Addendum No. 1

RE: Contract # C204202

WBS # 15BPR.20

I-26/US-74 WEST BOUND LANES AND EAST BOUND LANES OVER
GREEN RIVER.

SPANS A OR E BEARING AT BENTS 1 OR 4

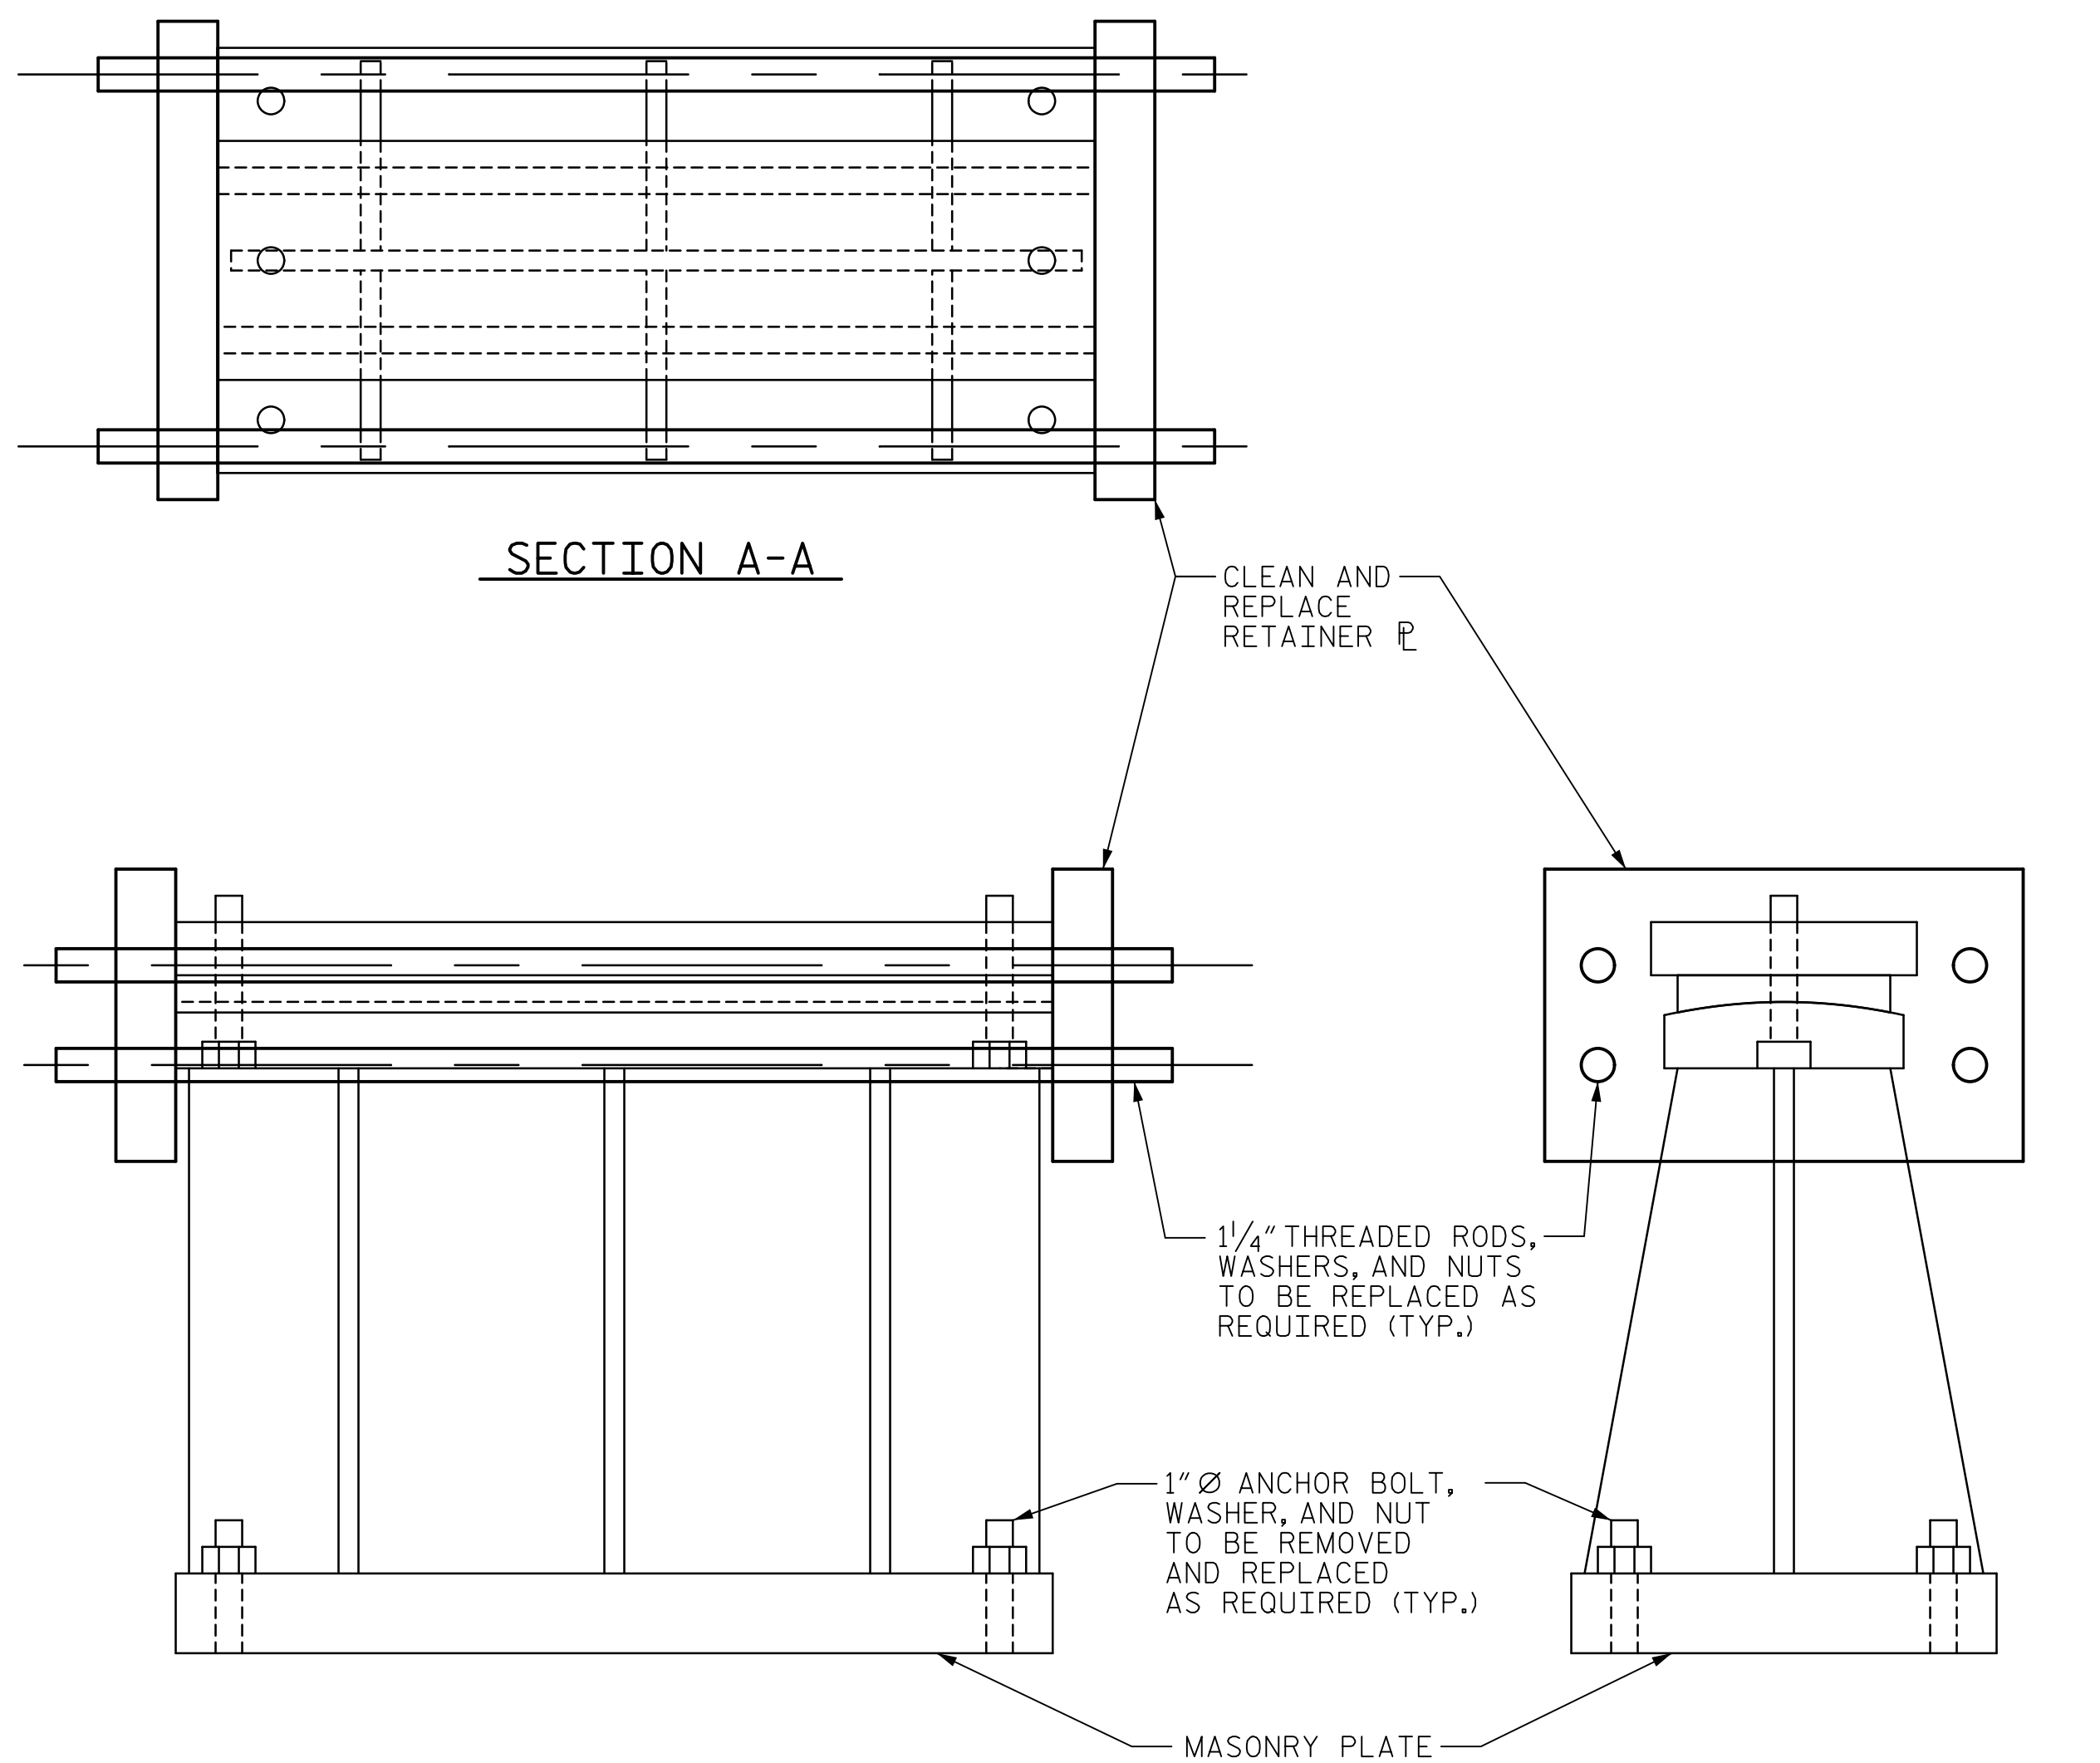
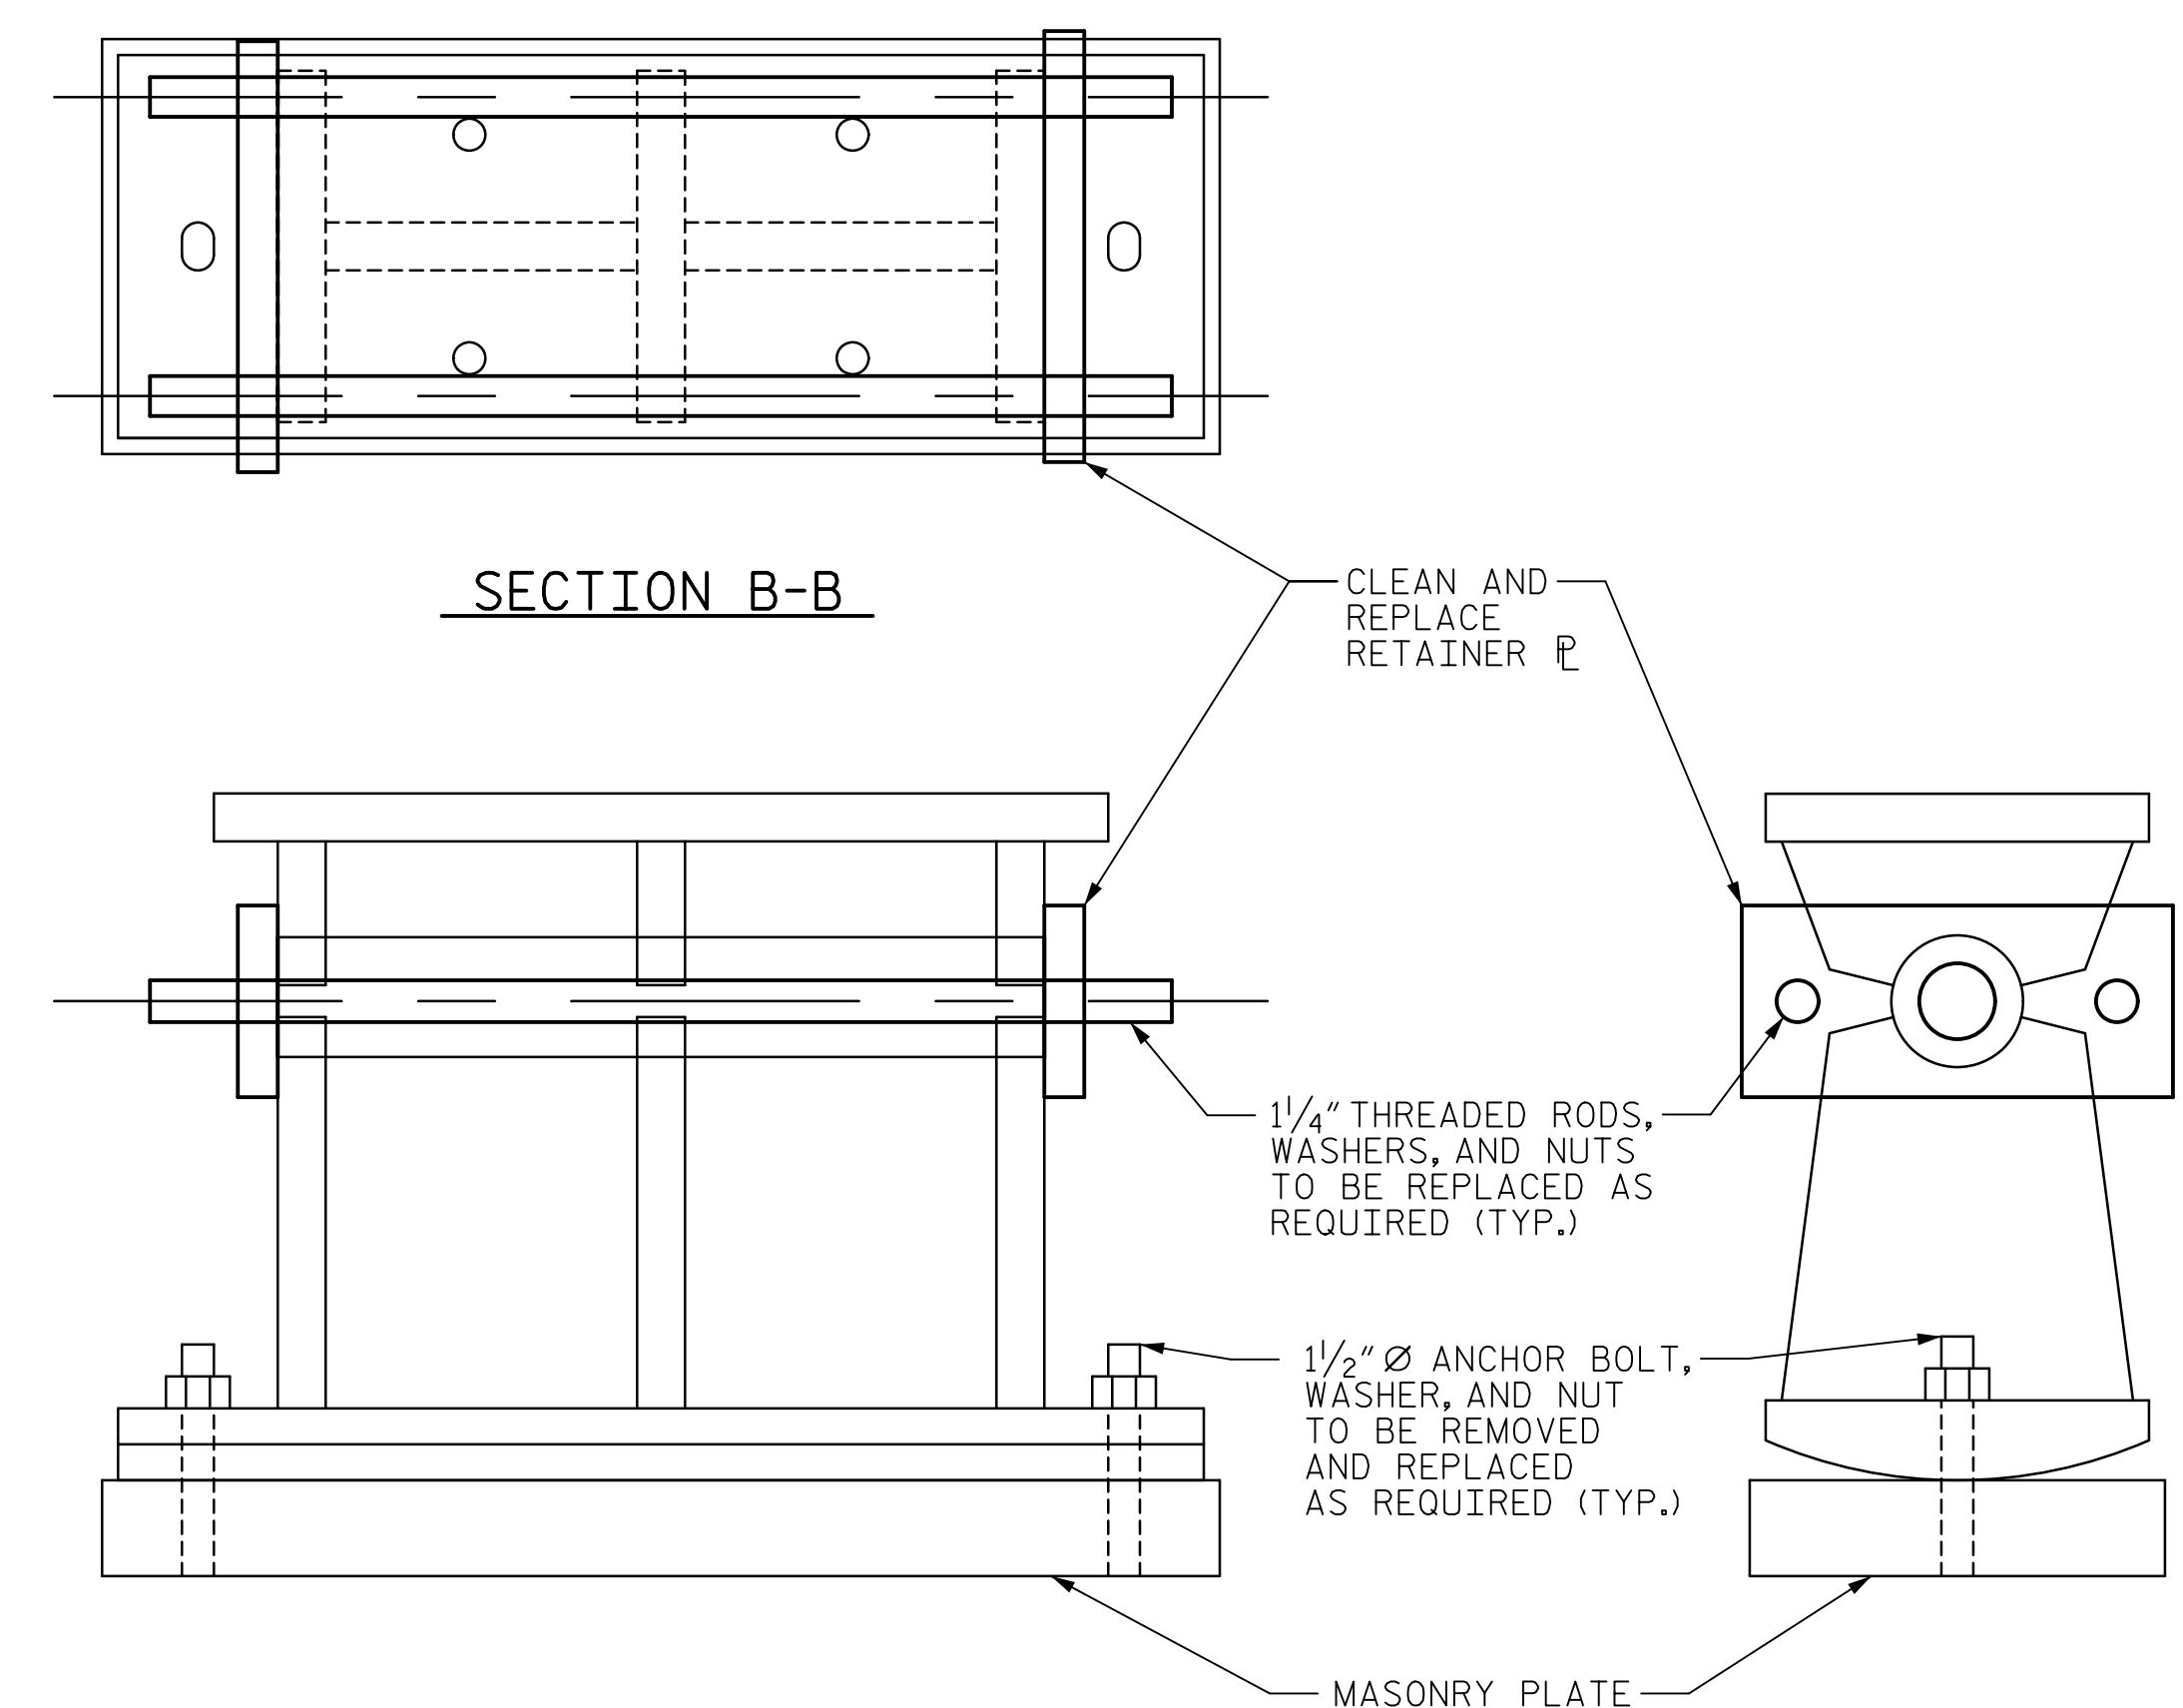
Sheet No.	Revision
S-7	Updated weld repair W4 quantities to a pay unit of each and a quantity of 5. Added quantities for bridge washing with a pay unit of each and a quantity of 30.
S-11	Added pay item for bridge washing with a unit of Each and a quantity of 30. Updated 3 notes: 1. demolition and construction work with pay item information, 2. the note about bridge washing, and 3. the note about removing utilities.
S-82	Added locations to weld repair W4
S-85	Added locations to weld repair W4
S-94	Changed weld repair W4 pay unit from lump sum to Each with a quantity of 5.
S-95	Deleted dashed line around girder 4 backstation bearing at bent 4.
S-96	Deleted the first note on the sheet referring to replacement of anchor bolts.
